Recommendation Report for Planning Permission for Works or Extension to a Dwelling

REF NO: AW/2/26/HH

LOCATION: 17A Fernhurst Gardens  
Aldwick  
PO21 4BA

PROPOSAL: Proposed side dormers and single storey extension.

Proposed North Elevation

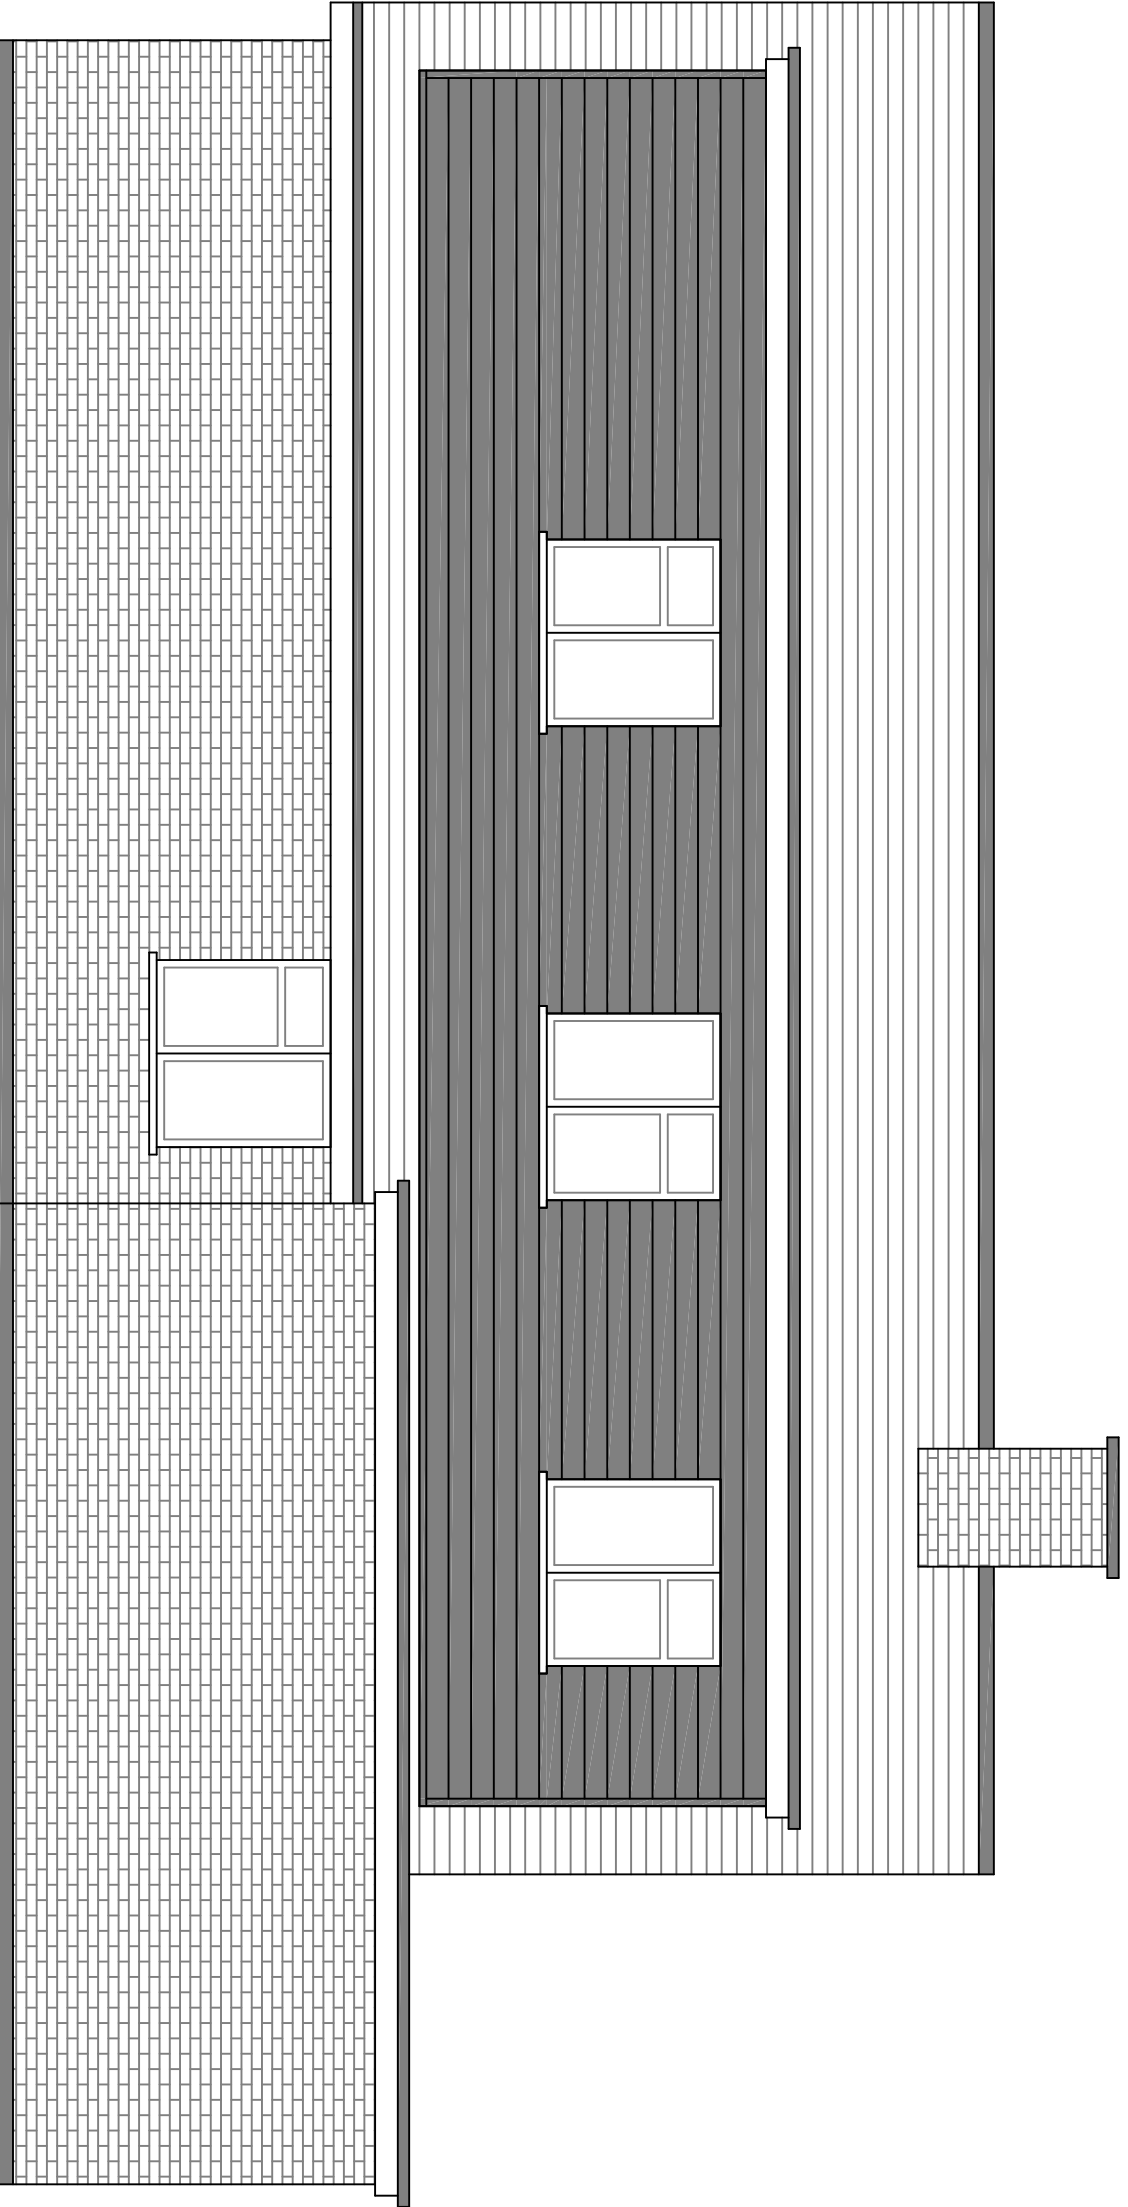
A larger dormer is proposed within the northern flank roof slope. This dormer would measure approximately 11.5m in width and 2.9m in depth, adopting the same flat roofed design approach as the smaller southern dormer. Matching materials are proposed, ensuring continuity with the existing roofscape. The northern dormer would include three two-pane windows, reflecting the design and colour of the other openings within the proposal. The northern dormer would be of a substantial scale and extend along almost the entire length of the northern roof slope and would not appear as a subservient addition within the roof slope, contrary to the ADG.

The north (side) facing dormer would incorporate three two-pane windows facing the flank elevation of 19 Fernhurst Gardens. This represents one additional window compared with the existing arrangement. The proposed rearmost window serving a bedroom would have some potential for overlooking the neighbouring property to the north, however, it would also face partially towards the roof slope where there are no openings, reducing the extent of any impact. It is further noted that the neighbouring property has erected a dormer of comparable scale without obscure glazing to its habitable room window, which is a material consideration. The existing roof also currently contains clear-glazed windows within the recessed dormer, and the proposed arrangement would not differ significantly from the established situation. On balance, the proposed dormers would not result in unacceptable overlooking and it would not be reasonable to require these windows to be obscurely glazed or non-openable below 1.7m above the internal floor level, given the existing fenestration and relationship between the host dwelling and neighbouring properties.
